**CITY OF PORTLAND, MAINE
Portland Community Health Center Renovations
Bid #2713**

Receipt of **Addendum No. 1** to the City of Portland's Bid #2713, **Portland Community Health Center Renovations**: is hereby acknowledged.

**CITY OF PORTLAND, MAINE
Portland Community Health Center Renovations
Bid #2713**

Layout Plan

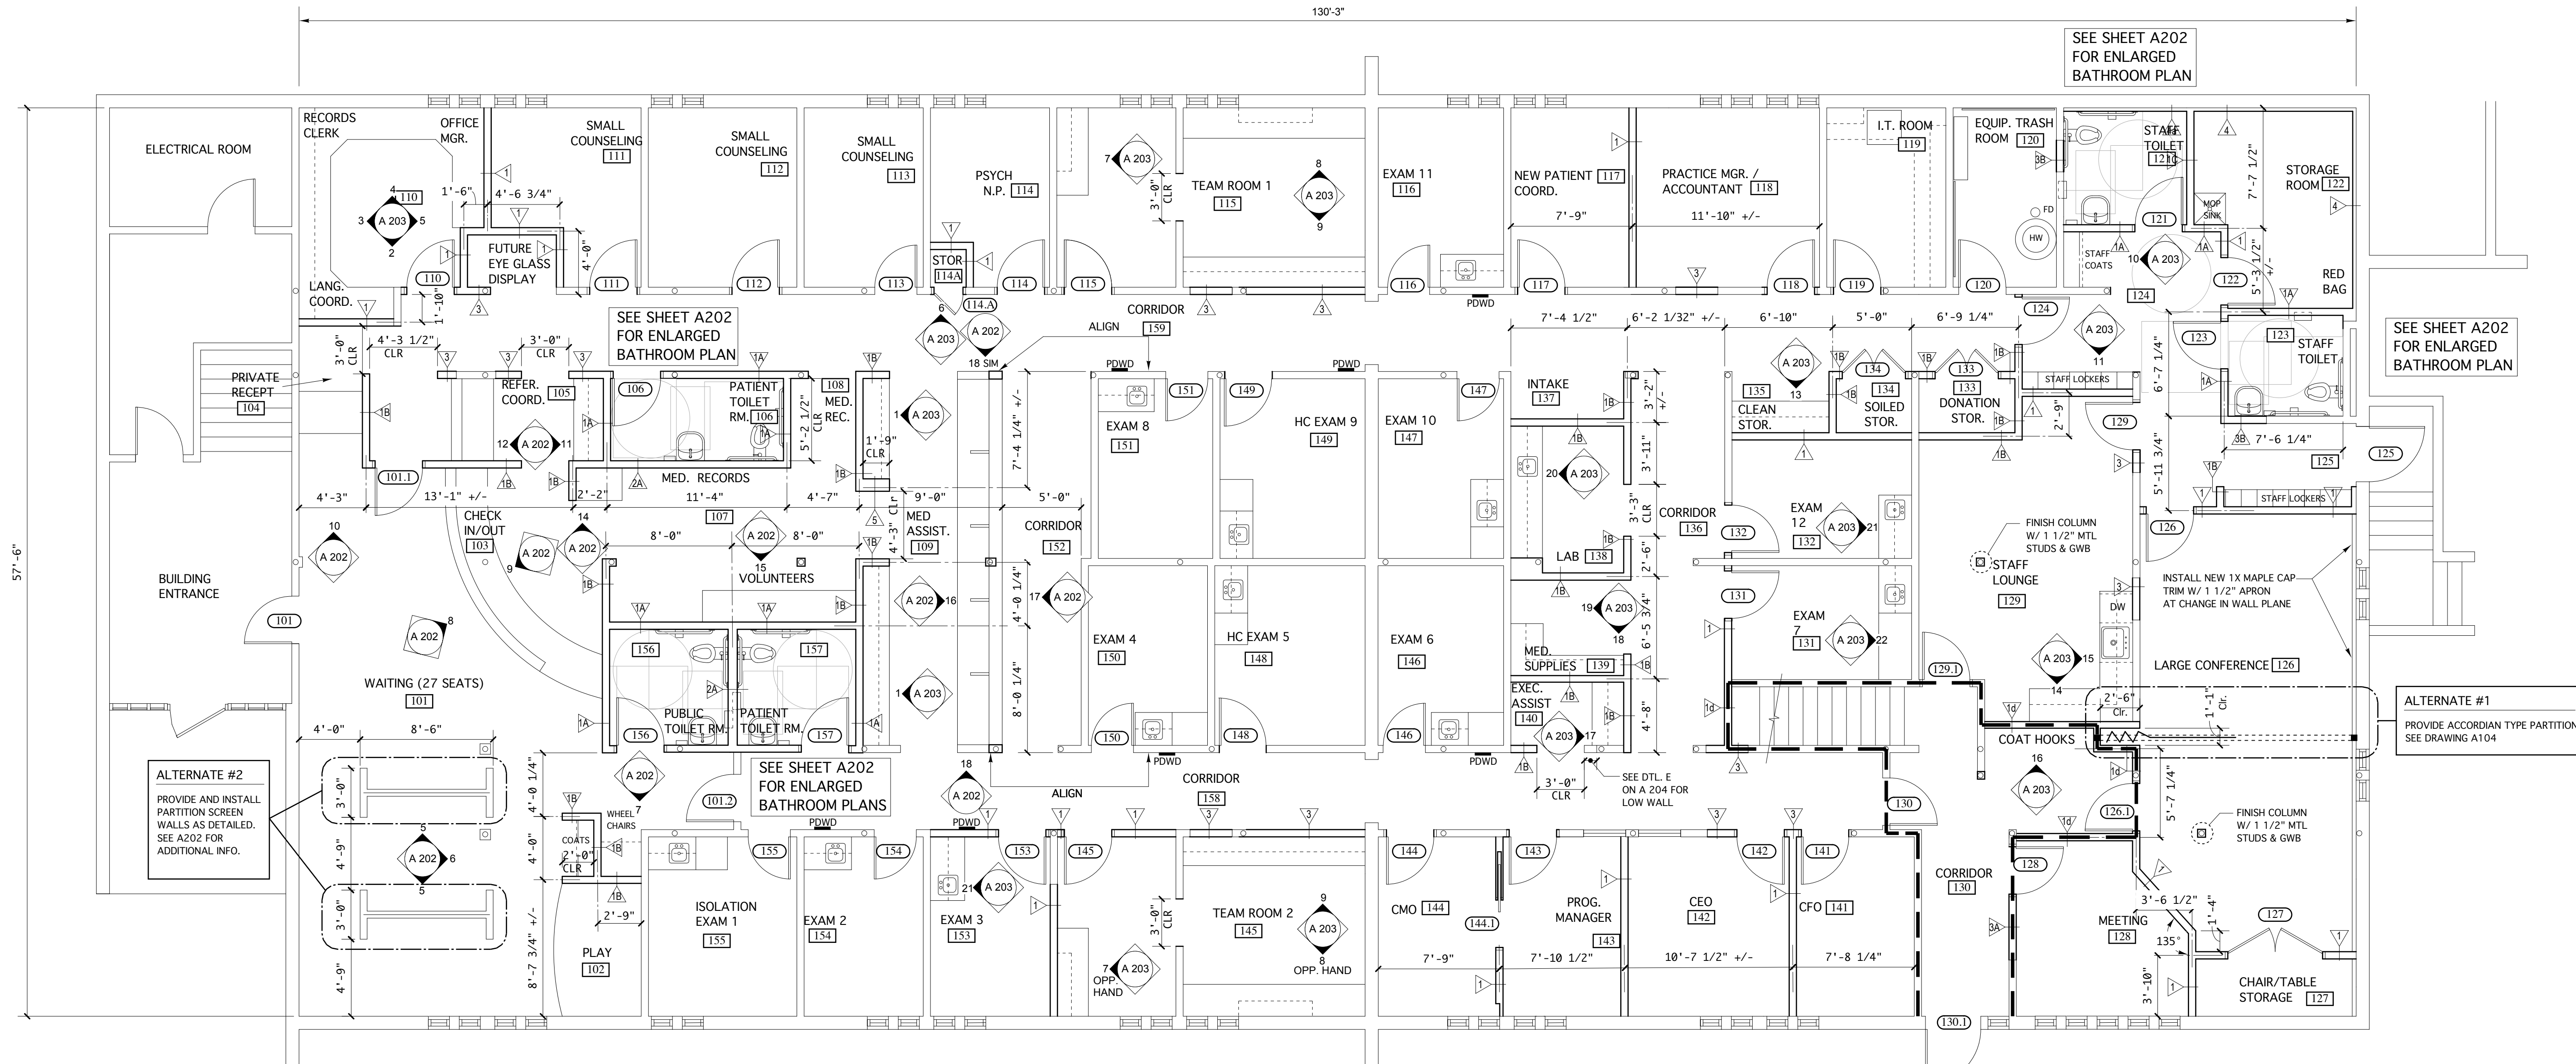
Will there be a cut sheet or sketch of some sort furnished in order for GC to determine proper installation, i.e., wall blocking and anchoring of the wall desks.

Please see attached literature.

Step 1. Position the WallWrite on wall or door in desired location and using the pre-punched holes as a template mark location of mounting holes (Keyhole slots). Make sure WallWrite is level.

Step 2. If hanging to wall studs. Drill 1/8" holes into the two marks through the wallboard and into the supporting studs. Insert two #8 x 1" screws into the two holes. Do not tighten all the way. Mount the WallWrite over these two screws and tighten.

Step 2a. If mounting to drywall or plaster wall use the KapToggle™ anchors supplied in hardware kit. Drill two 1/2" holes in wall where previously marked. Use below instructions to properly install anchors.

Step 2b. If mounting to a concrete block wall use the plastic wall anchors. Drill two 3/16" holes. Insert anchors into the holes. Screw two #8 x 1" anchor screws into the two anchors. Do not tighten all the way. Mount the WallWrite over these two screws and tighten.
